Ribble Valley Borough Council  
Housing & Development Control

Application no: **3/2021/0082**

Address: **24 Blakewater Road Clitheroe BB7 2FT**

Proposal: **Proposed ground floor extension to rear elevation and repositioning of garden wall to enlarge amenity space / improve parking arrangement**

proposed site plan (1:500)

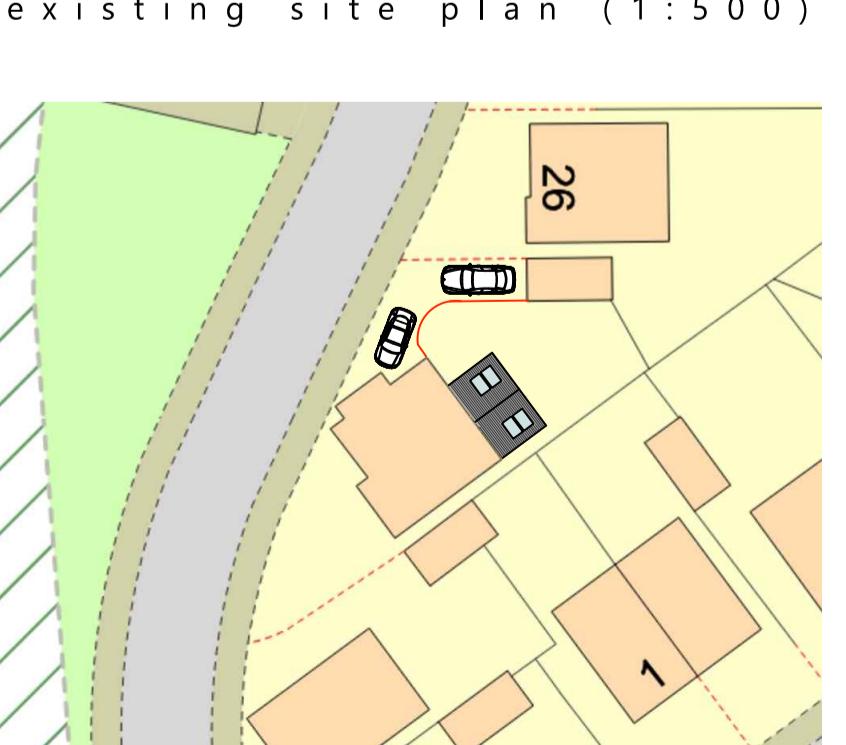
Whilst the existing parking provision would be retained as a result of the proposal, I would need to be satisfied that the proposed improvements to the existing parking arrangement can be achieved without causing a detrimental impact to other road users.

I ask that a detailed plan of the proposed amendments to the existing parking arrangement is provided, detailing the proposed dimensions, safe access and manoeuvrability as well as the repositioning of garden wall.
